Permit Number: 041566

has permission to 32'x44' SFH w/ 2 car garage, 16' x 16' rear deck & 42' from former's porch

AT 100 Hope Ave (lot #2) 390 A008001

City of Portland, Maine - Building or Use Permit Application

0500

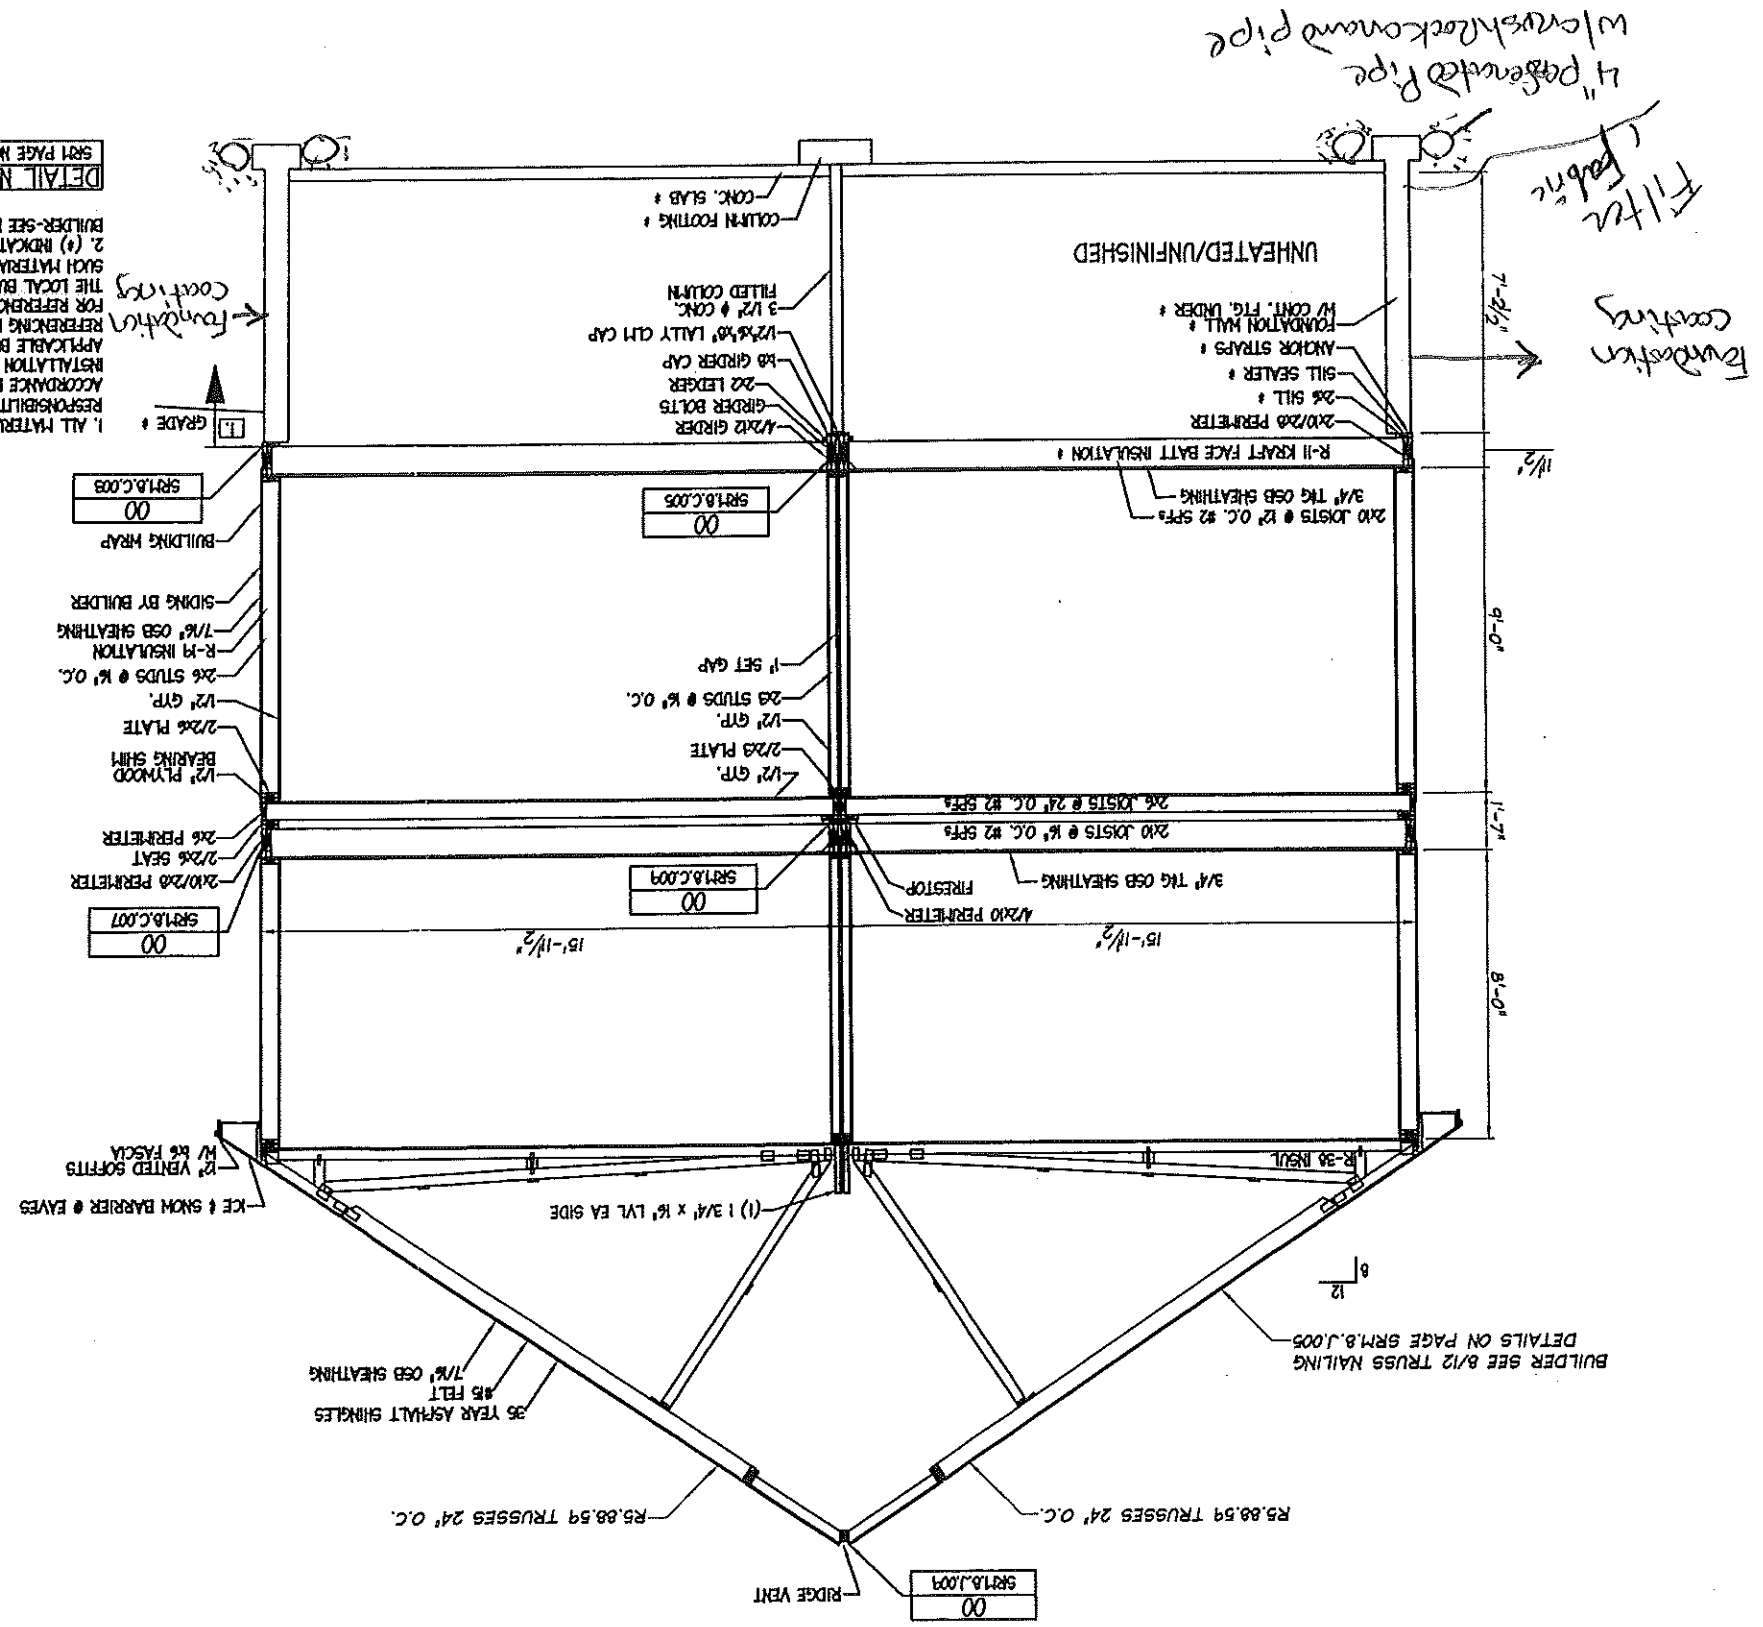
Sawn tube for Rear deck to be 4" tapered precast concrete post w/ 7'6" max spacing! 10' out from building!
2x8 @ 16 O.C.
